Greatford Parish Council Closing Summary Statement for Mallard Pass Solar Farm Planning Examination Deadline 10.

Greatford Parish Council

Plate 7: Typical PV Array

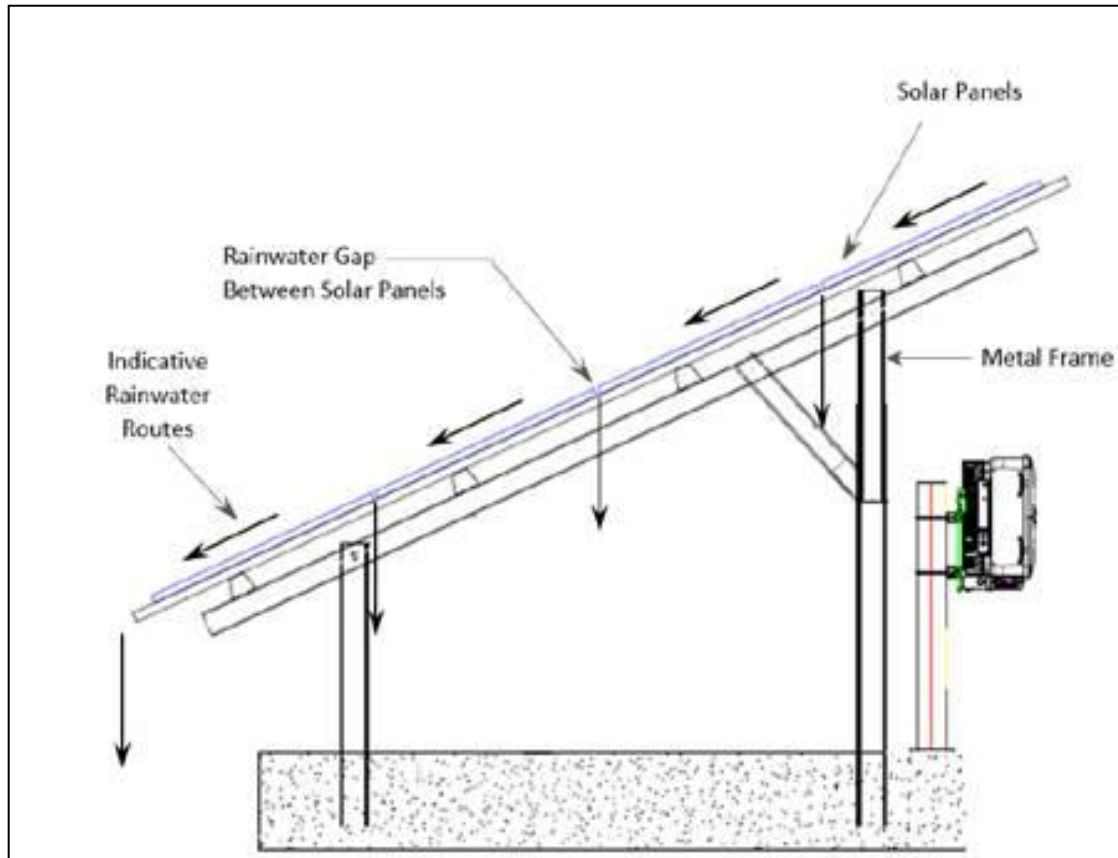
The covering of large areas the soil with solar panels (effectively a roof) will concentrate the rainfall onto a significantly smaller area of the soil, below the drip lines of the panels which will reduce the area of soil receiving the rainfall and thus the available reservoir within the soil to store water.

This water will not "spread evenly" underneath the panels as was suggested by the applicant, but will move under gravity down into the soil. When the soil is at field capacity the water will then flow overland as runoff, and more rapidly into the drainage system. This increased runoff will more quickly arrive in the West Glen and Greatford than is currently the case.

Plate 9: Establishing Grass Mix Under PV Drip Line³¹³²

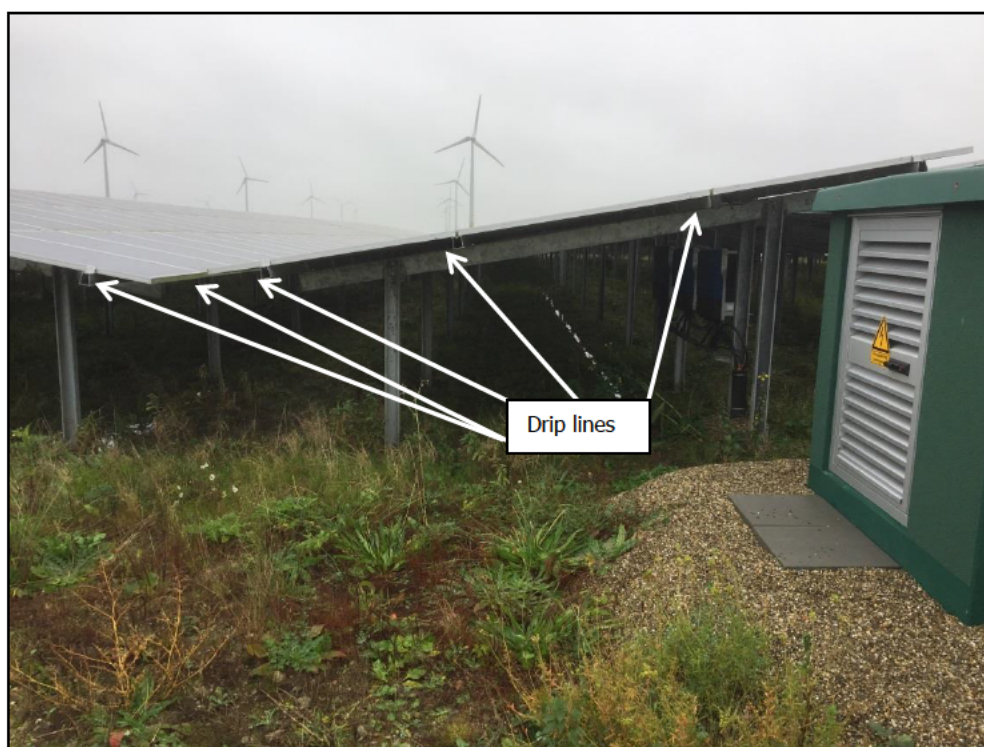
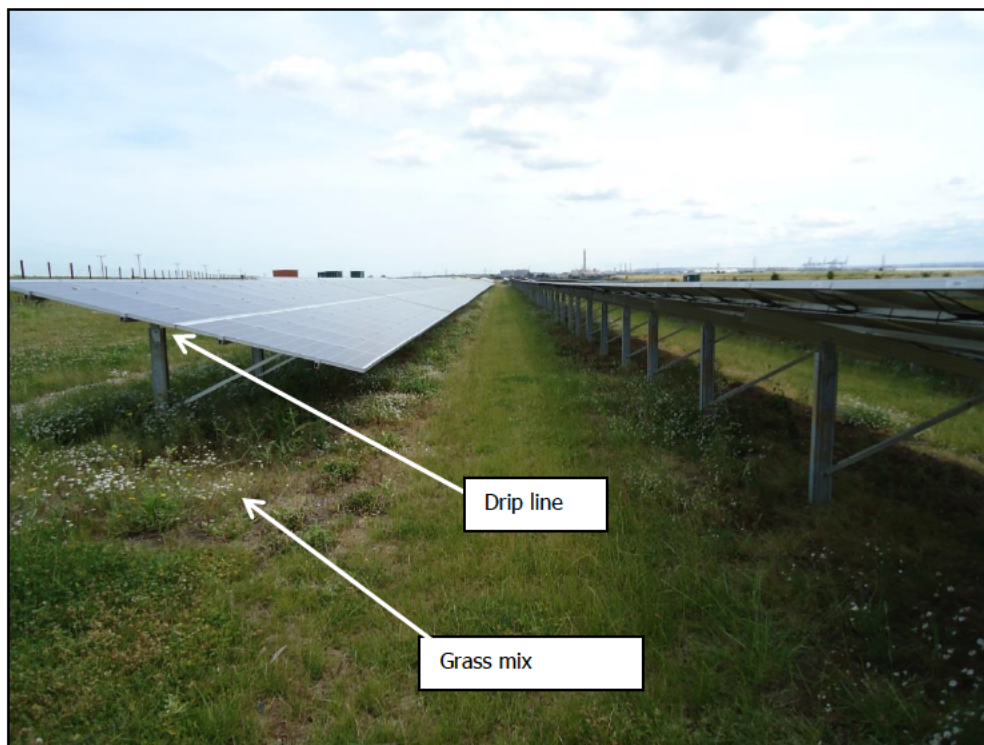
One of the key measures proposed by the applicant to ameliorate the potential for overland flows of water and to improve water infiltration into the soil is to establish grassland. Greatford Parish Council have suggested that grassland establishment should take place 18 months prior to the commencement of construction to allow the hard wearing but slow growing species proposed by the applicant to become fully established. A fully established grass sward will be more resilient to the rigours associated with trafficking and construction and may help (if trafficked correctly) to enhance the soils resilience to damage.

The methodologies proposed by the applicant to establish grassland are fundamentally flawed as they do not allow time for establishment prior to construction, and in some cases propose establishment after construction.

The biological activity in grassland beneath a solar array is around 25% of that observed in open ground; grassland establishment in the drier, cooler and shaded conditions beneath a solar array will be significantly compromised and establishment will be at best slow and at worst a failure.

Poorly established grassland (or bare soil) will be unable to perform the functions required of it by the applicant, ie: improving water infiltration rates, preventing runoff and the soil erosion associated with runoff.
